Our ref: NO/2013/105935/01-L01
Your ref: 3/2013/0981
Date: 23 December 2013

OUTLINE APPLICATION FOR RESIDENTIAL DEVELOPMENT COMPRISING 20 DWELLINGS (INCLUDING 6 UNITS OF SOCIAL HOUSING), 3 CLOSE CARE APARTMENTS AND A 60 BED CARE HOME (ALL MATTERS RESERVED FOR SUBSEQUENT APPROVAL)

LAND OFF CHATBURN ROAD, CLITHEROE, BB7 2AZ

DRAWING TITLE
Site Plan - Indicative Layout

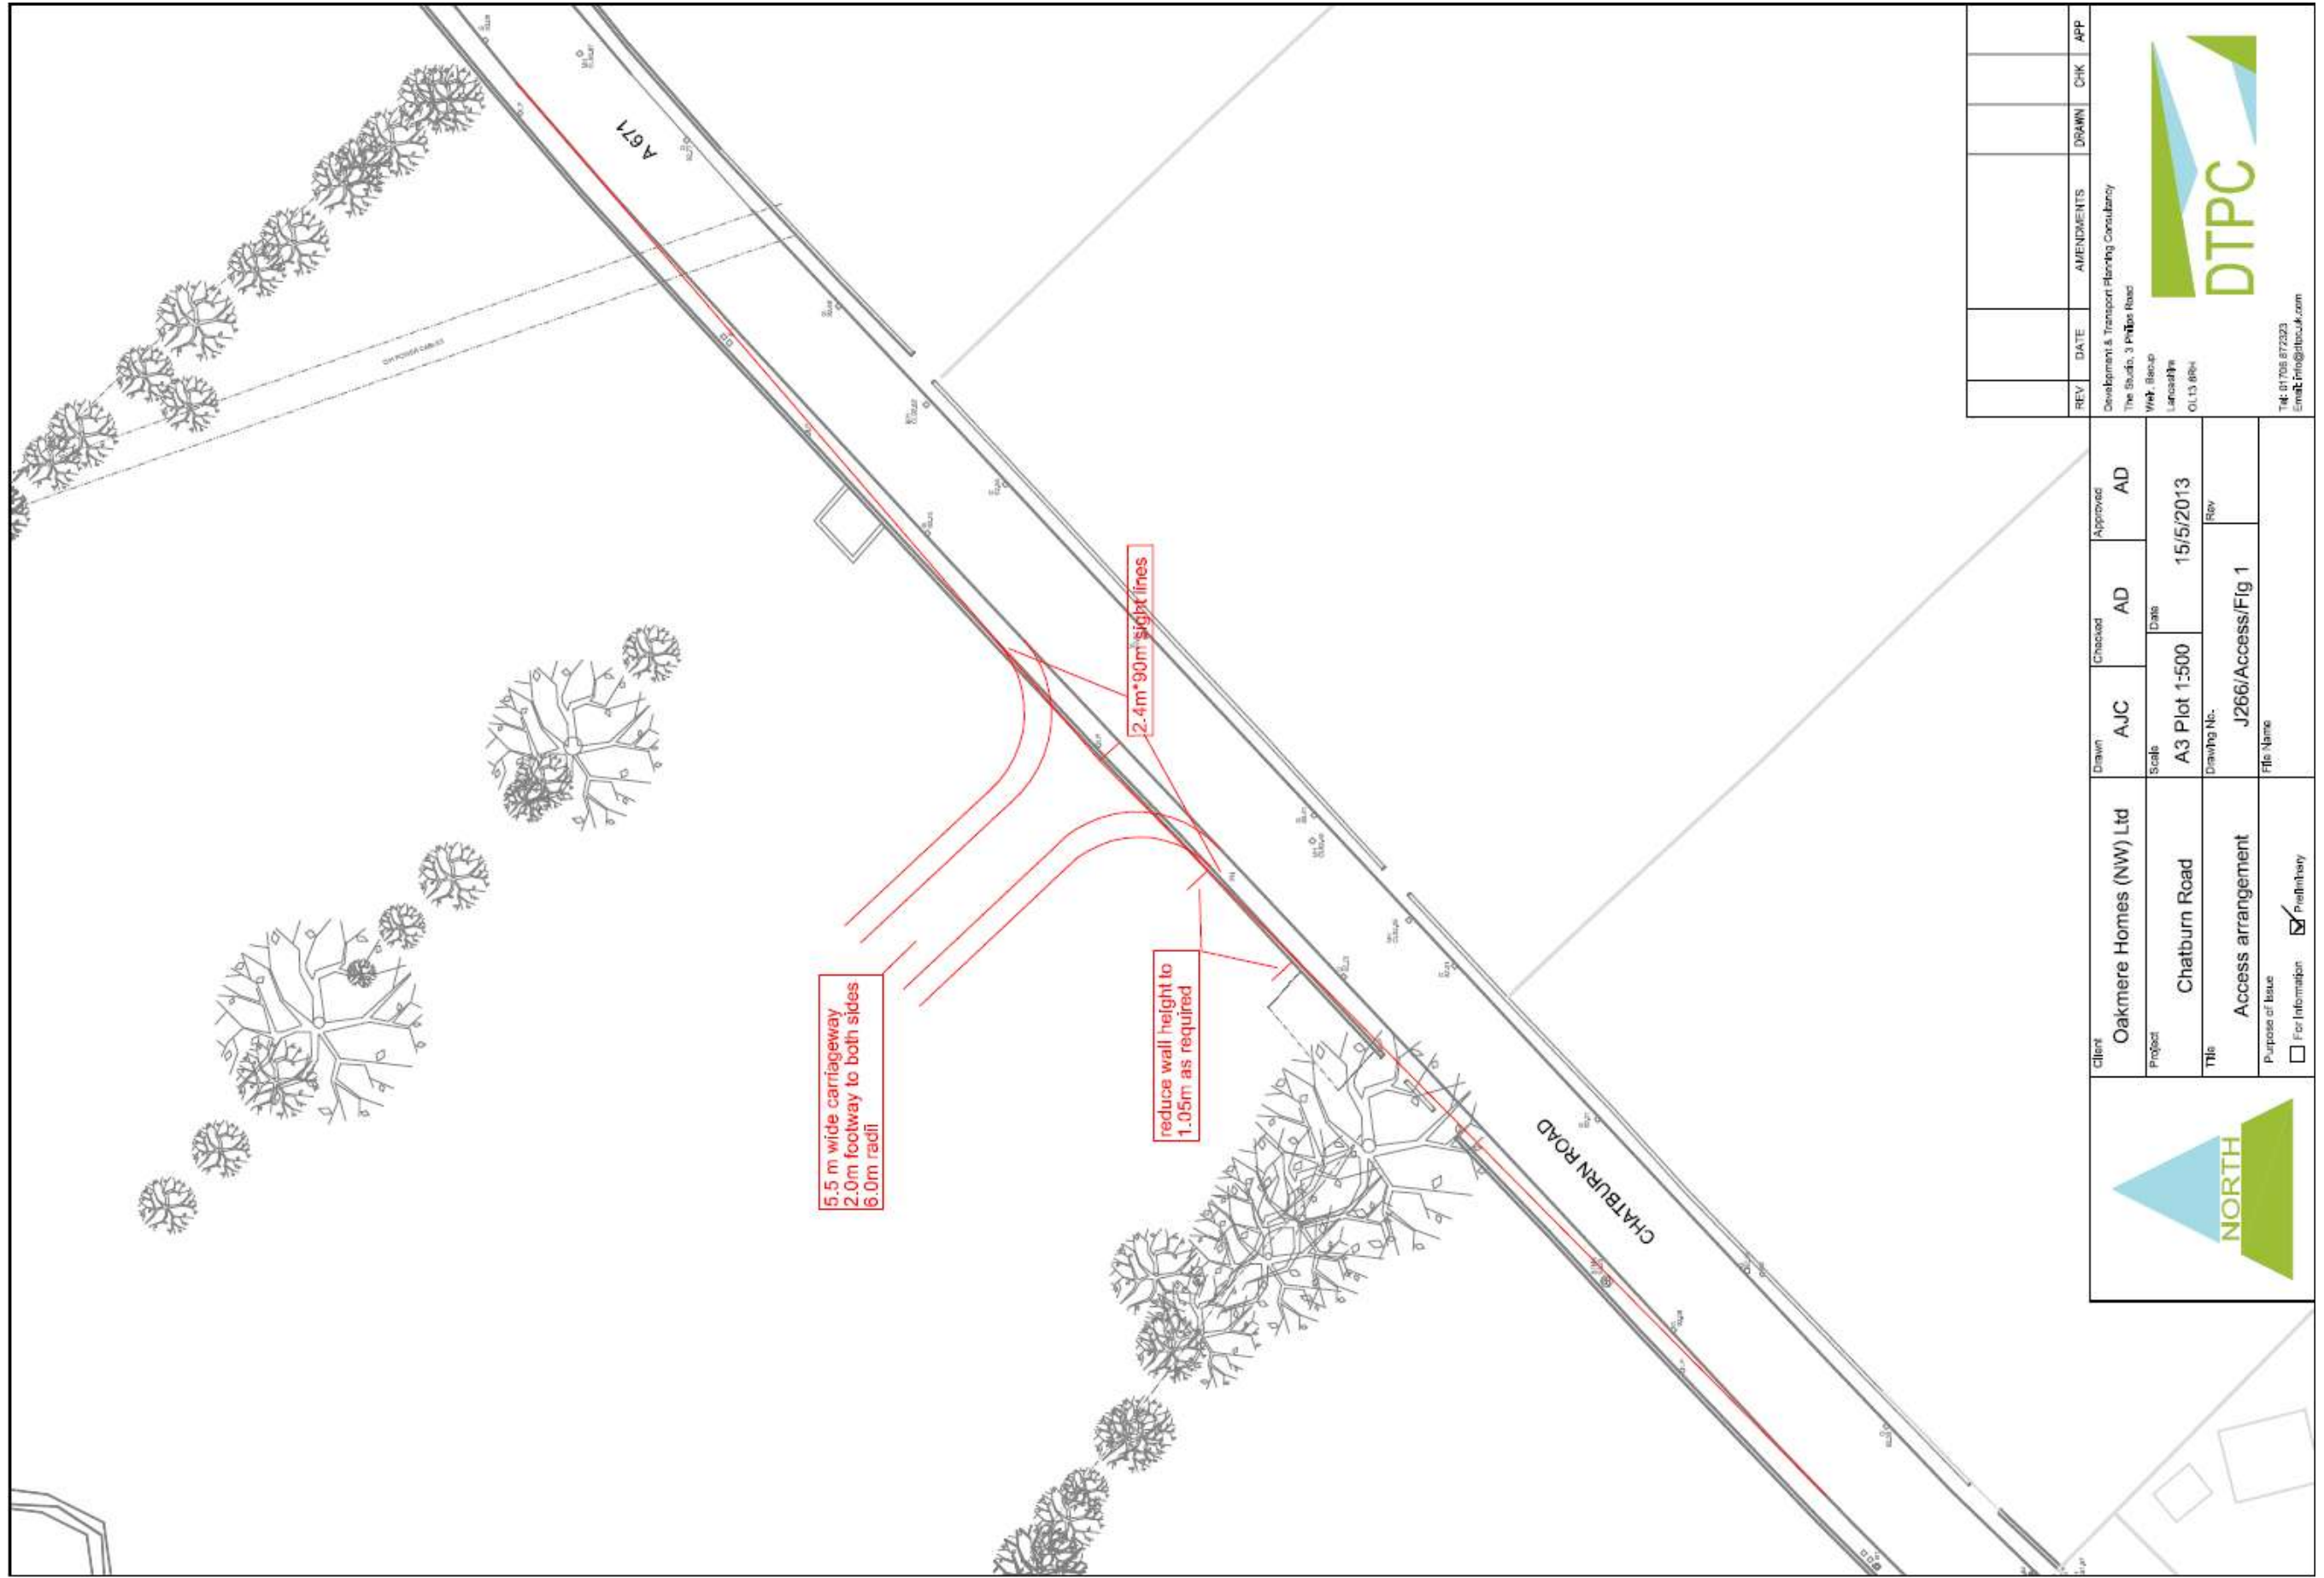
The illustrative masterplan (drawing 13-037-110) indicates that the proposed dwellings numbered 12 to 17 will have rear facing domestic gardens adjacent to the watercourse. The proposed layout is likely to require revising to accommodate the 5 metre buffer as it should be clear of any private garden spaces or built development.

The illustrative masterplan (drawing 13-037-110) indicates a proposed footbridge crossing Pimlico watercourse. The Environment Agency seeks wherever practicable to ensure that watercourses are crossed by bridges rather than culverts.

This buffer zone shall be measured from the top of the bank and domestic gardens should not be incorporated into the buffer zone to the watercourse. This would avoid problems such as fragmentation of the buffer by fencing; the placing of garden rubbish near the bank; the introduction of non-native species into the buffer; and pressure for inappropriate bank retention works.

Prior to the commencement of development plans for the footbridge should be submitted to and approved in writing by the local planning authority.
